**From:** [Charles Judson](#)  
**To:** [A47 Blofield to North Burlingham](#)  
**Subject:** A47 Blofield - North Burlingham - Hearing Action Points  
**Date:** 06 September 2021 13:18:09  
**Attachments:** [Acle Neighbourhood Plan extract - policy 5.pdf](#)

Please accept the following responses on behalf of Broadland District Council to the Hearing Action Points:

Issue Specific Hearing 1 – Draft Development Consent Order (dDCO) - Tuesday 17 August 2021

|  | SUITABILITY |

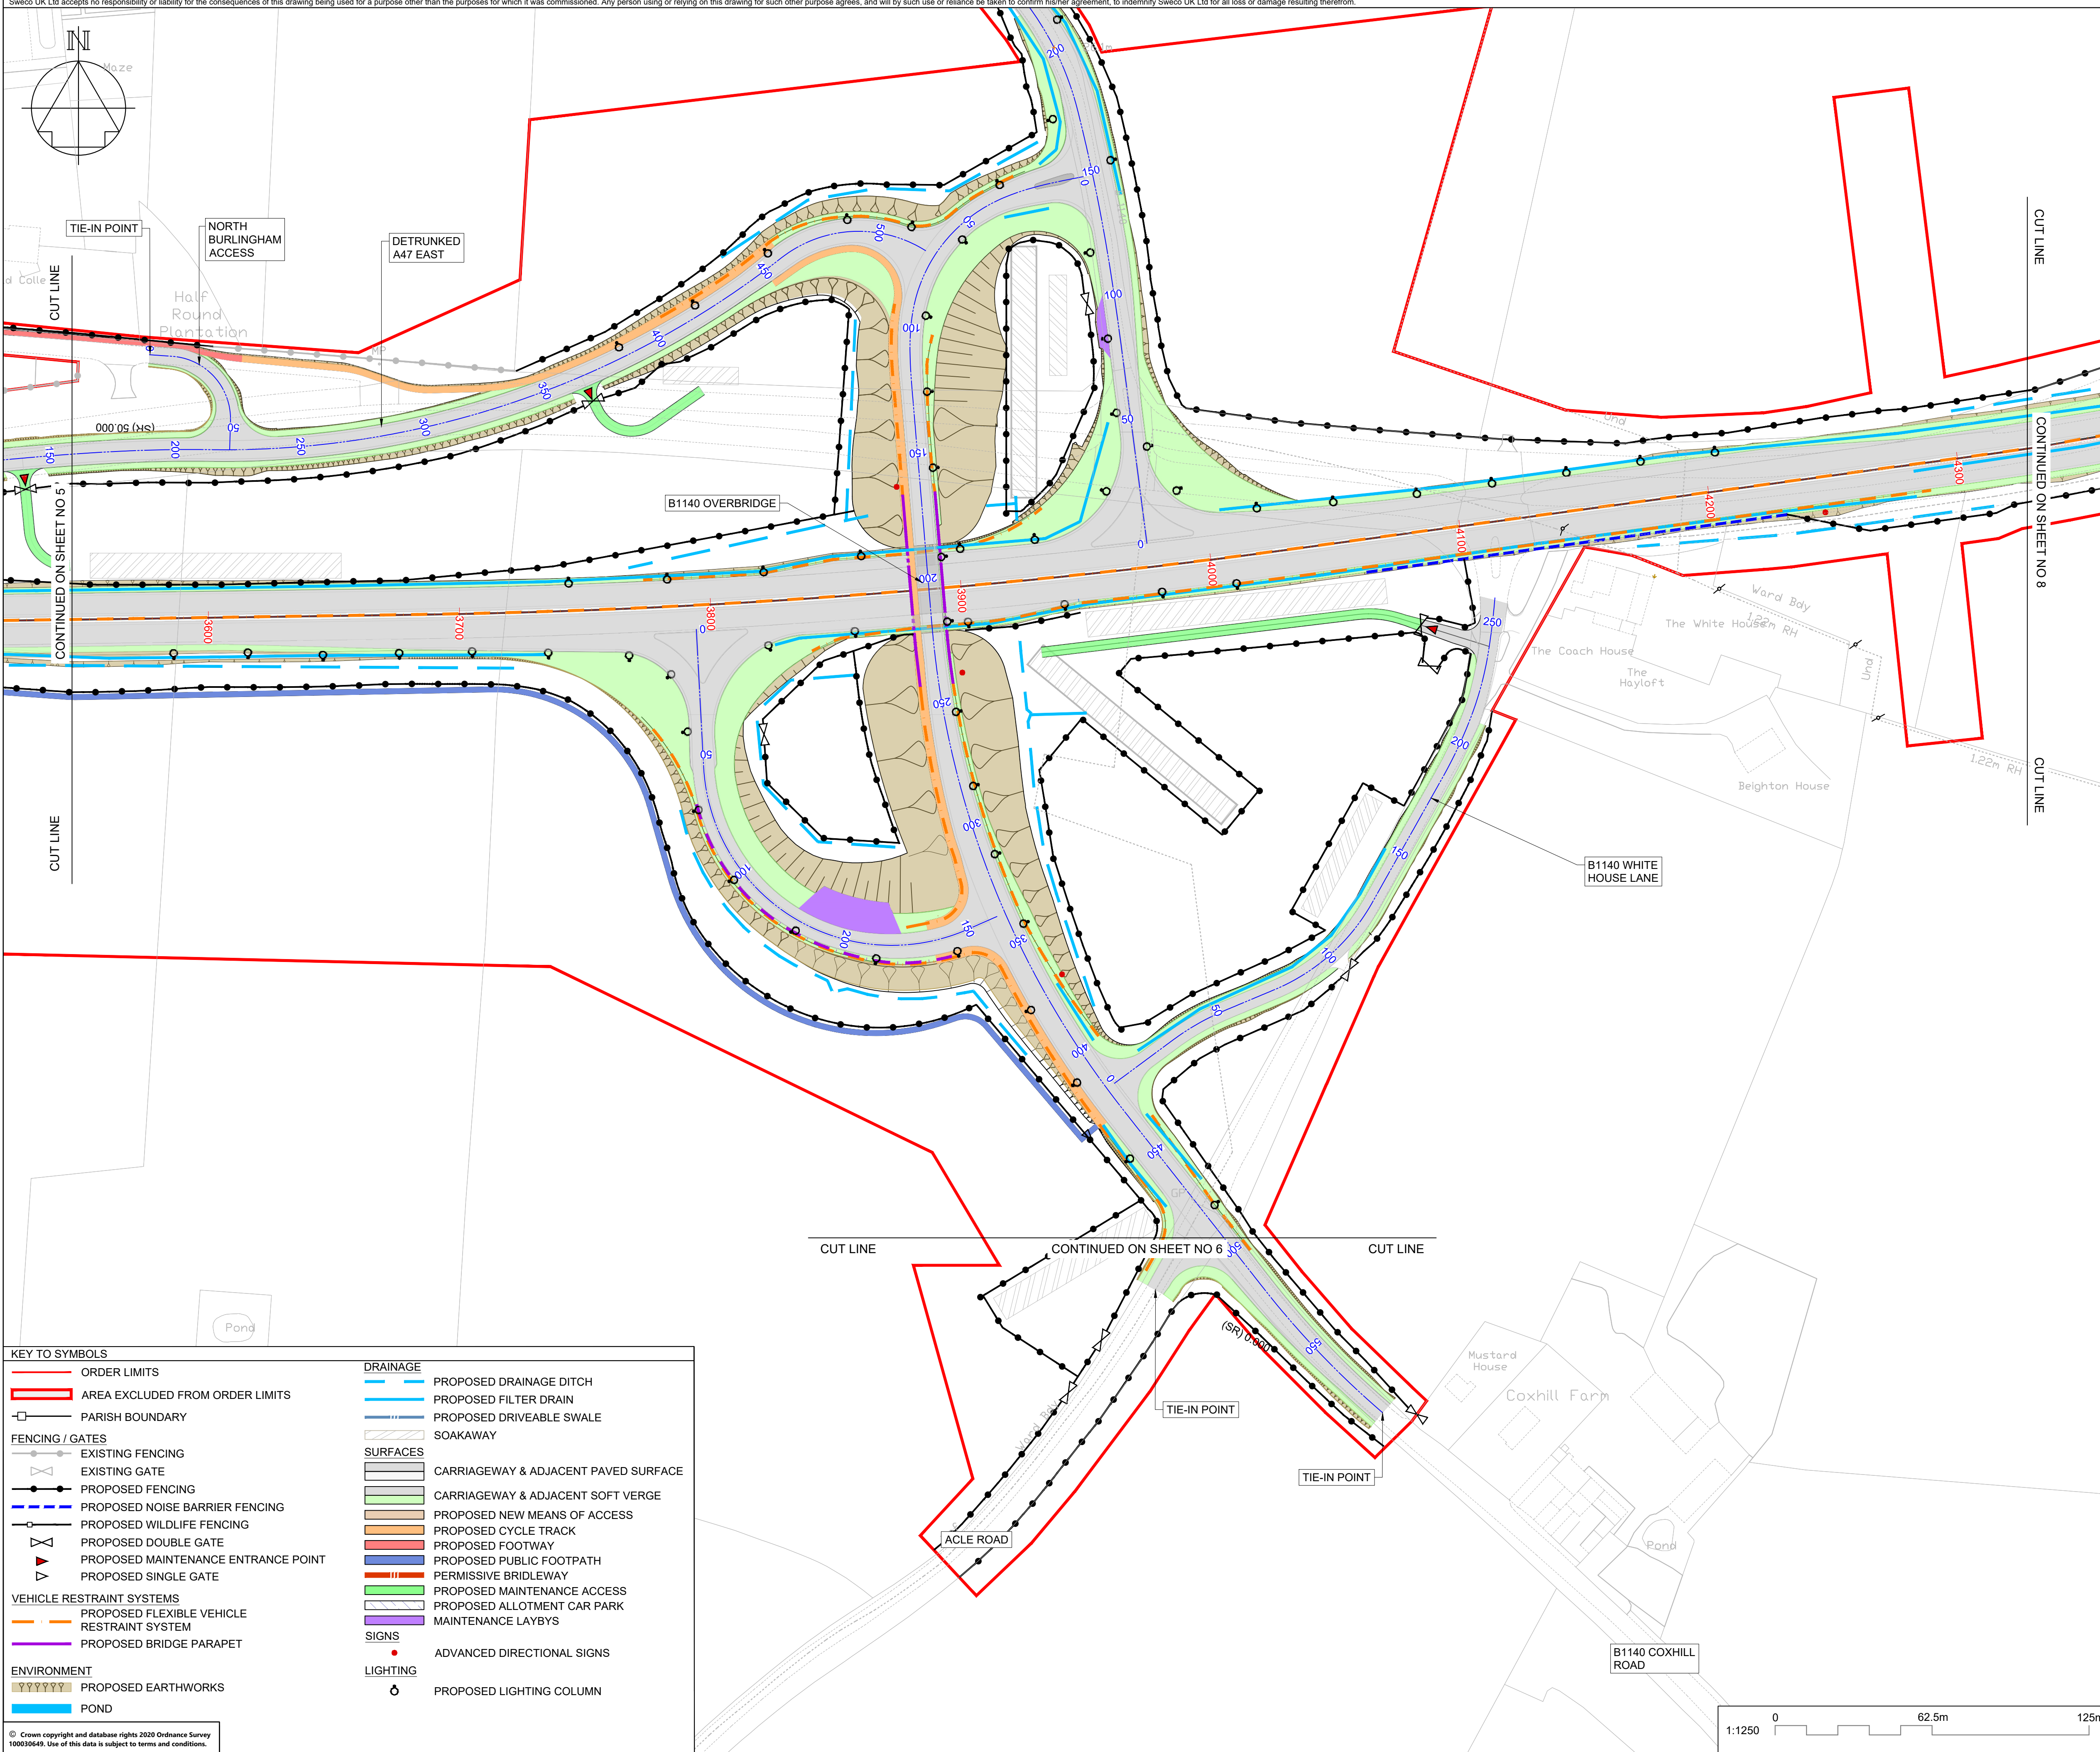
Item 11 – Broadland District Council considers that the general arrangement plans, which do not include details of elevations/sections/design/materials of the structures, would be insufficient for the purposes of R3.
